<b>Application Ref:</b>	3/2021/0167	 <b>Ribble Valley Borough Council</b> <a href="http://www.ribblevalley.gov.uk">www.ribblevalley.gov.uk</a>
<b>Date Inspected:</b>	17/03/2021	
<b>Officer:</b>	AB	
<b>DELEGATED ITEM FILE REPORT:</b>		<b>REFUSED</b>

<b>Development Description:</b>	<b>2 Bridge End Whalley Road Billington BB7 9NU</b>
<b>Site Address/Location:</b>	<b>Internal alterations to create open plan/ upside down house, with additional mezzanine level. External alterations include new window openings and Velux rooflights.</b>

5 EXISTING EAST
1 : 50

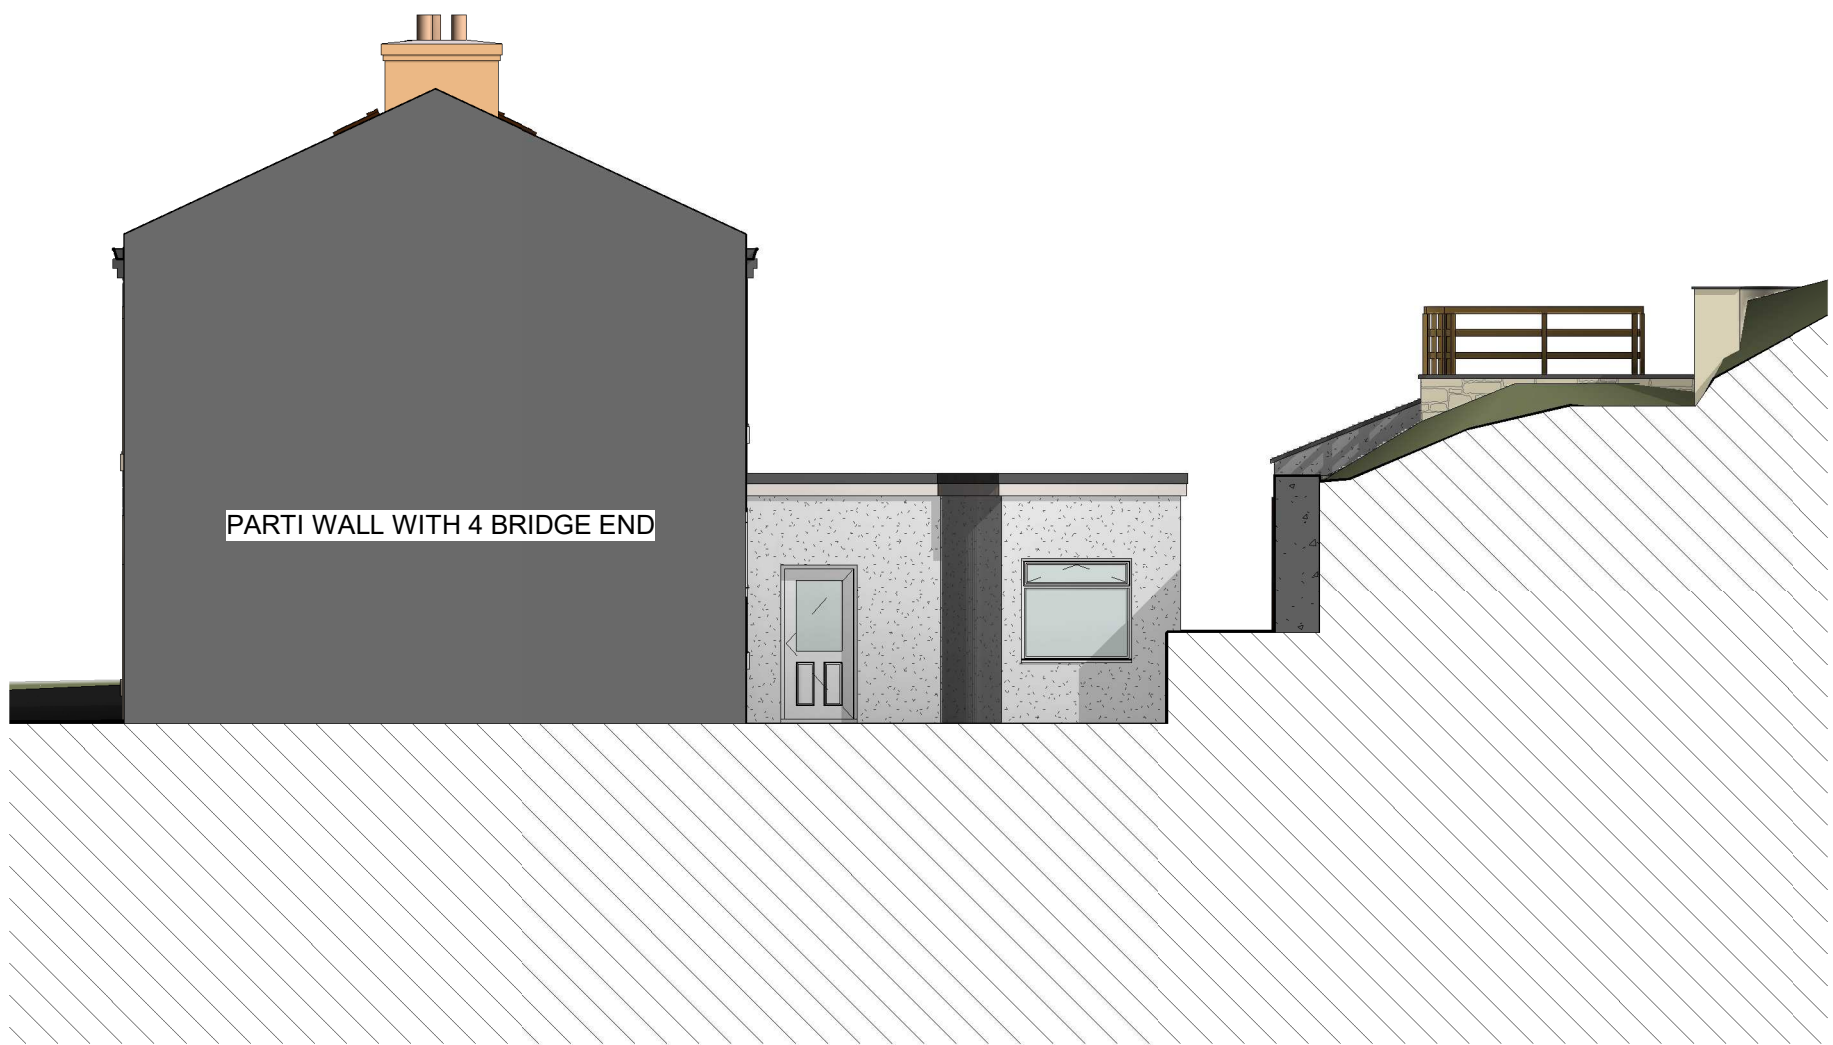
There are significant concerns however regarding the proposed new window opening on the gable elevation at first floor. At present the property has a structured window arrangement, with matching windows at ground and first floor adding to the building’s character and appearance. The introduction of a new window at first floor would be seen as a harmful addition, would fail to respect the historic window arrangement and the existing symmetrical layout.

4 PROPOSED EAST  
1 : 50

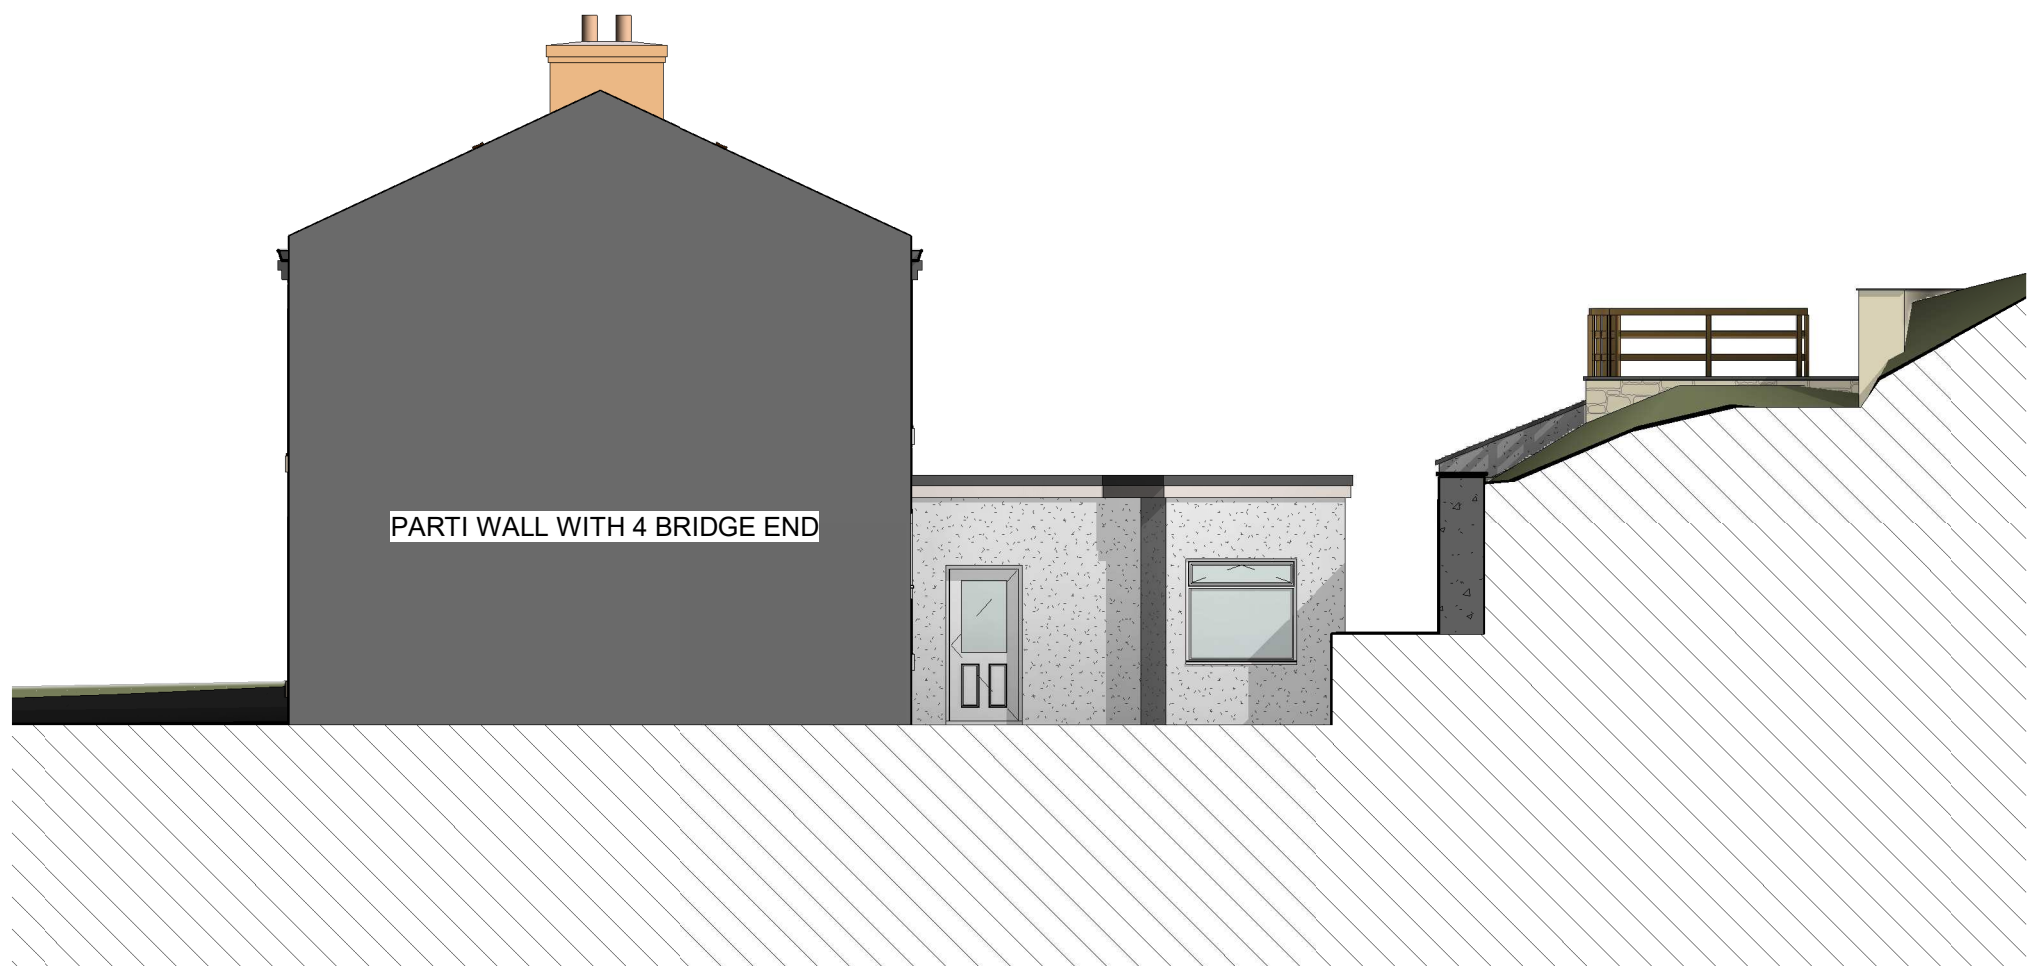
Having regard to the gable’s visual prominence in the Conservation Area and adjacent to the main route through the village it is considered that this proposed new window opening would result in such detriment to warrant refusal of the planning application.

The proposals would impact negatively upon the application property which is identified as a ‘Building of Townscape Merit’ in the Whalley Conservation Area Appraisal. The proposed new first floor window on the east elevation would be harmful to the character and appearance of the building and would fail to preserve or enhance the character or appearance of the Whalley Conservation Area contrary to Core Strategy Key Statement EN5 and policies DME4, DMG1 and DMH5.

It is considered that the removal of the chimney stack and insertion of new conservation style rooflights would not impact negatively on the appearance of the building or the significance of heritage assets. There are small projecting rooflights present on the front and rear roof slopes as existing and their replacement with flush conservation style rooflights would represent an improvement. The chimney stack would be removed from the hipped roof and in its place an additional conservation rooflight would be installed. This is not considered to be injurious to the character or appearance of the building.
